# **APPLEGREEN PLC**

## **DEADLINE 2 SUBMISSIONS**

**M42 Junction 6  
Development Consent Order Application**

## **APPENDIX 2 - RESPONSE TO HIGHWAYS ENGLAND'S COMMENTS ON APPLEGREEN'S RELEVANT REPRESENTATION [REP1-002]**

**Figure 6 Junction 5A Proposed Design - With MSA**

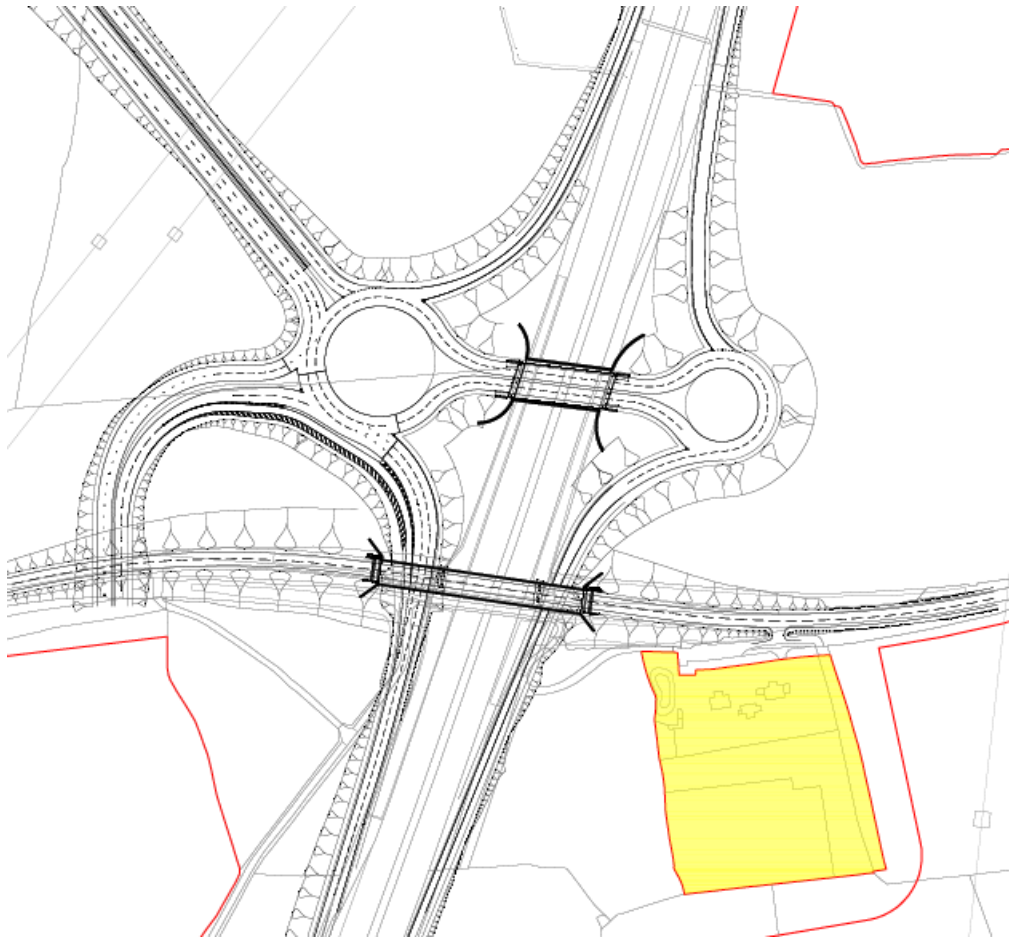
Reference Number	Applegreen RR comment	Highways England response	Applegreen further response
			<p>It is difficult to comment accurately on the suitability of the proposed junction layout shown in Figure 4 as it is an “Indicative Layout” rather than an engineering drawing. Even so there must be serious concerns about the impact on the proposed Solihull Road Bridge. The slip road under the bridge would be significantly wider. The Solihull Road Bridge would have to be longer, not only to accommodate the wider carriageway, but any forward visibility along the free flow left turn slip. While traffic on the slip road proposed in the DCO scheme only has to see as far as the entry onto the roundabout, traffic on the introduced free flow left turn slip needs to be able to see the required stopping sight distance along the road ahead. This lengthening of the Solihull Road Bridge would extend the section of Solihull Road that needs to be at high level further to the west adjacent to the ancient woodland.</p> <p>At paragraph 6.3 of Appendix 4, Highways England indicate that the proposed modifications have been assessed and validated through traffic modelling but no results of that</p>

PLAN OF B4102 SOLIHULL ROAD OVERBRIDGE

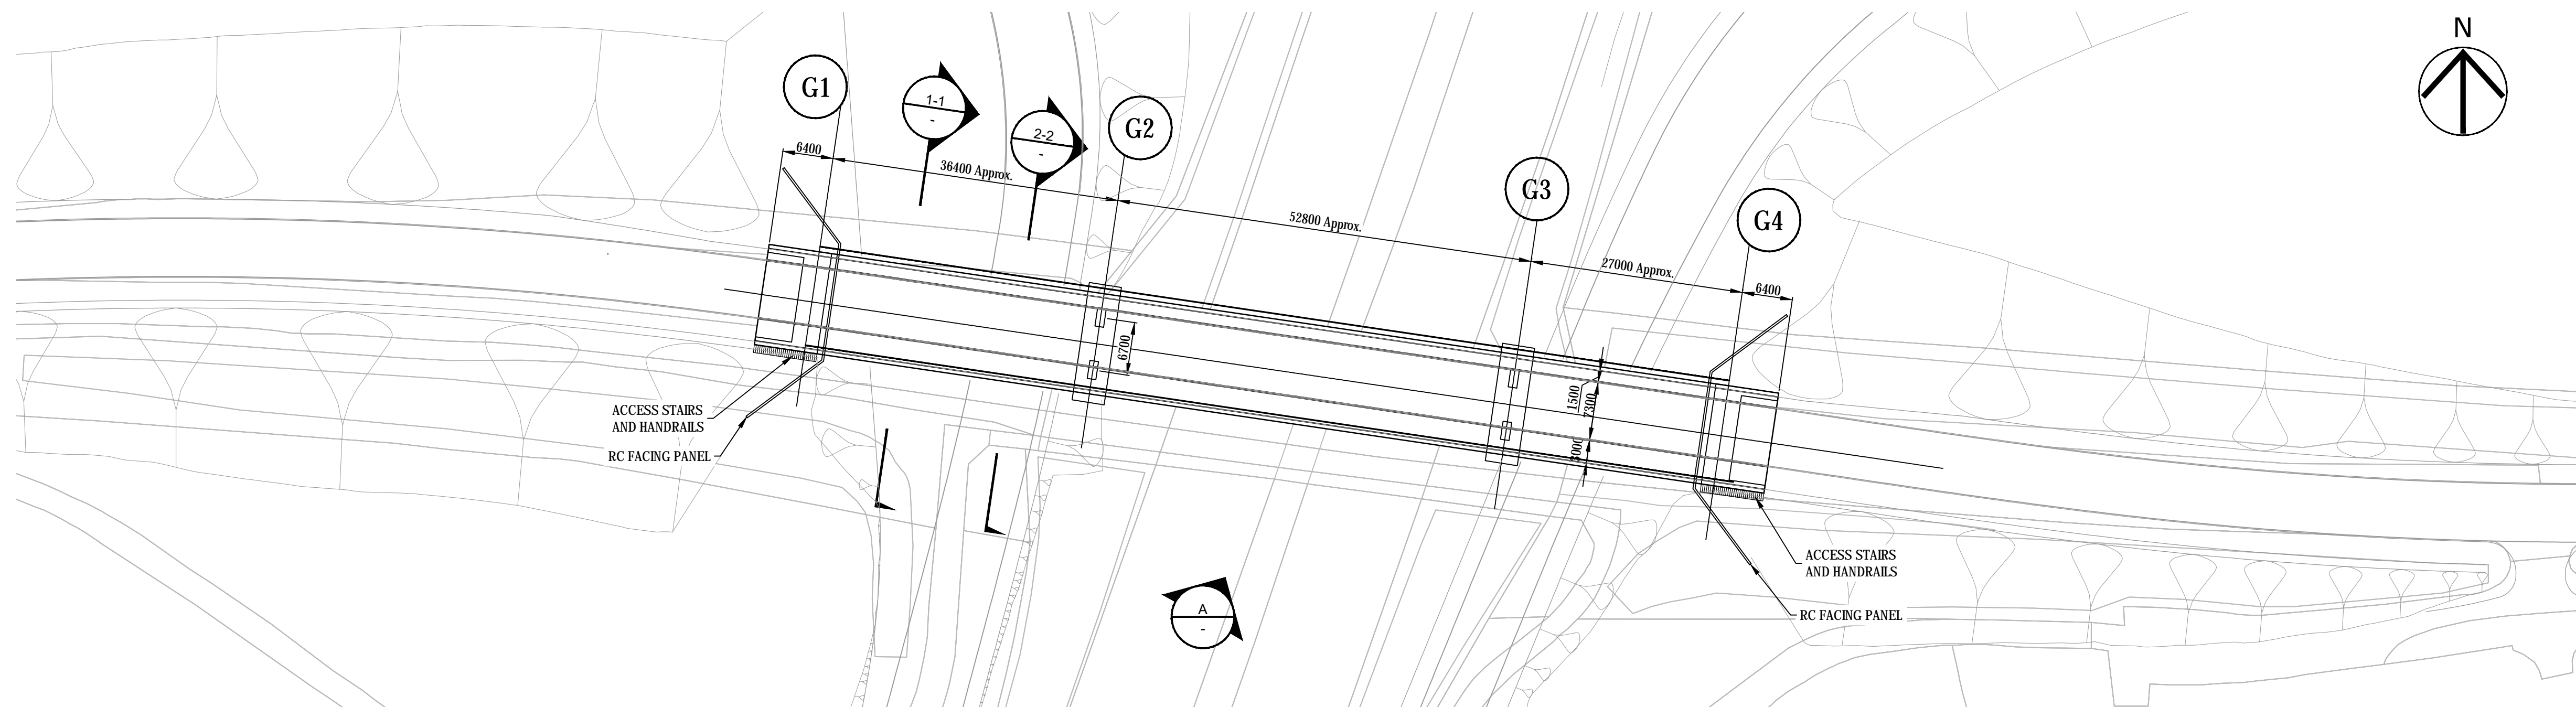
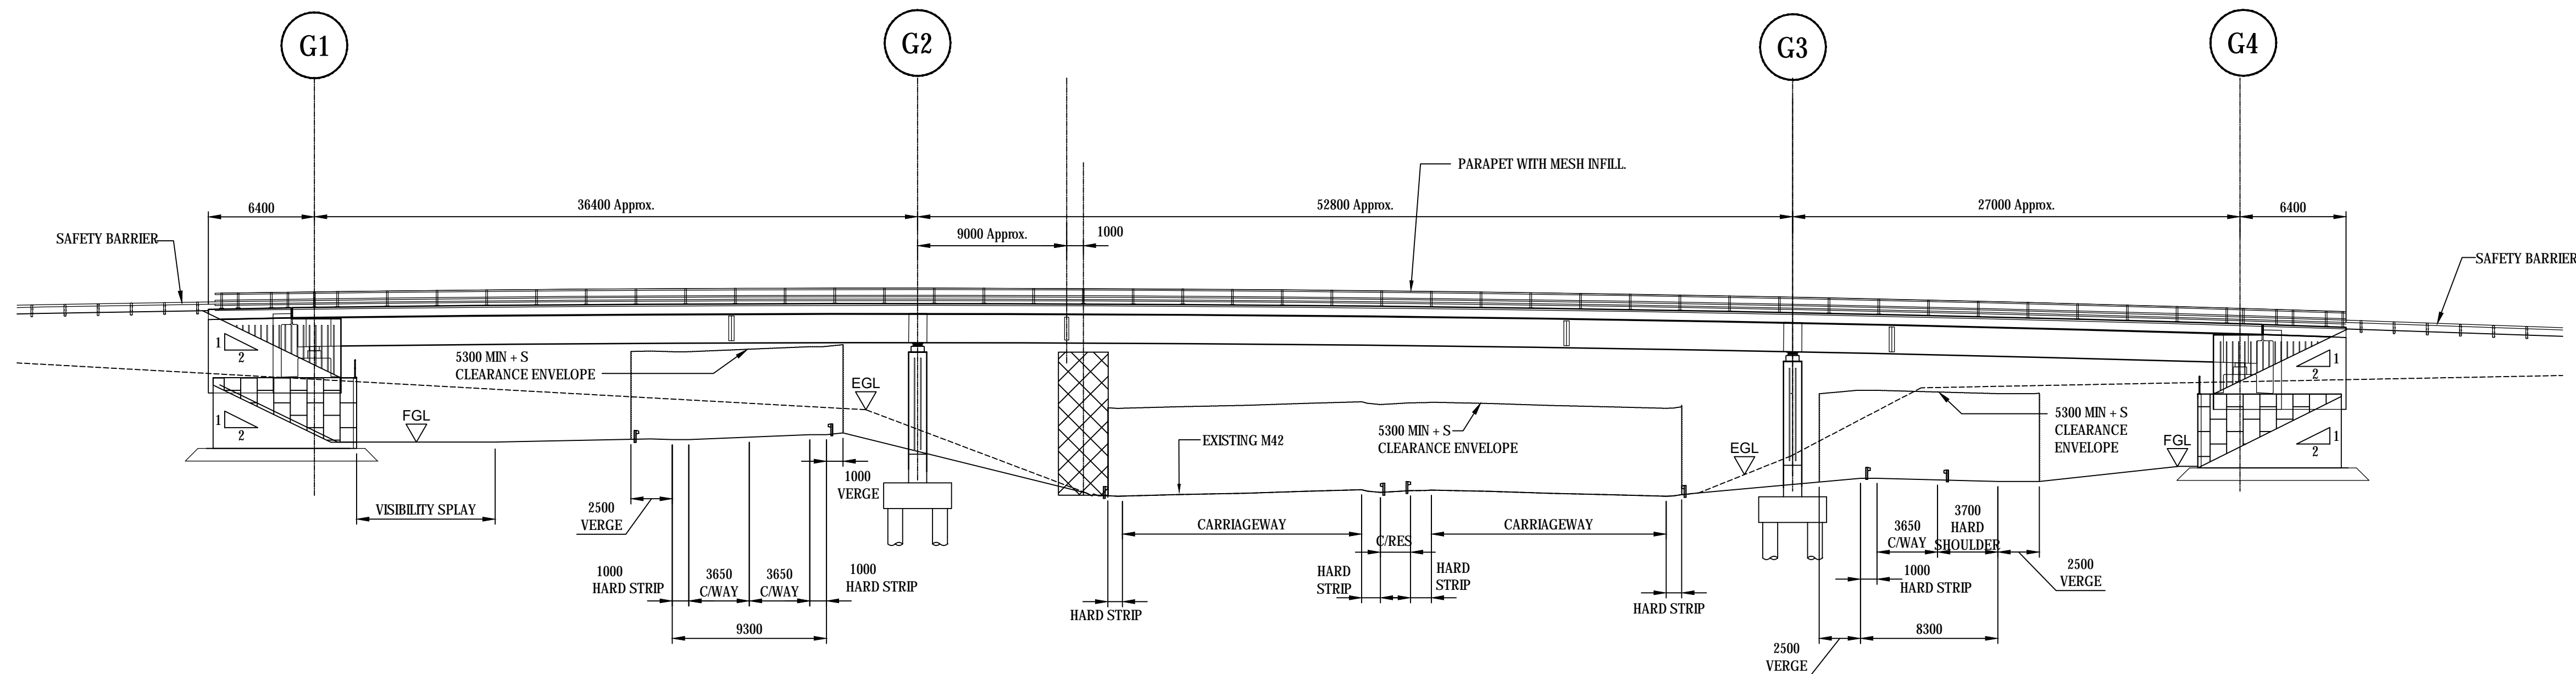
Reference Number	Applegreen RR comment	Highways England response	Applegreen further response
	<p>drivers on the slip road to see further to the left along this free flow slip. From the sketch layout provided, it appears that the Solihull Road bridge proposed in the DCO Scheme will obstruct the ability to see along the free flow left turn slip and it is possible that the bridge, if built as currently proposed, would need to be demolished and rebuilt to accommodate the forward visibility required by the access to the MSA.</p>		
RR011u	<p>Accordingly it can be seen that seeking to 'retrofit' the MSA into the DCO Scheme will have a huge impact on the latter. It should also be noted that these design features / requirements do not form part of the Extra MSA planning application, which has been submitted in detail in respect of access. In short, this means that in the most likely scenario that the DCO is granted before the Extra MSA, the Extra scheme is not deliverable without needing to go through a new, separate planning application process, and securing a subsequent approval. As such, the DCO scheme will either be very well developed, or even complete, before the massive disruption that would be caused by the MSA materialises.</p> <p>Applegreen cannot see how such disruption could ever be compatible with the DCO Scheme objectives, or acceptable to HE.</p>	<p>In the event that it was necessary for the MSA scheme to be varied, this would be a matter for resolution between MSA Extra and Solihull Metropolitan Borough Council as the local Planning Authority.</p>	<p>The MSA scheme would need to be varied and Highways England's response is correct that this would have to go back to SMBC. However, at present, Highways England, as a key consultee on the Extra MSA application, is not objecting to that proposal despite it being incompatible with the DCO scheme.</p>
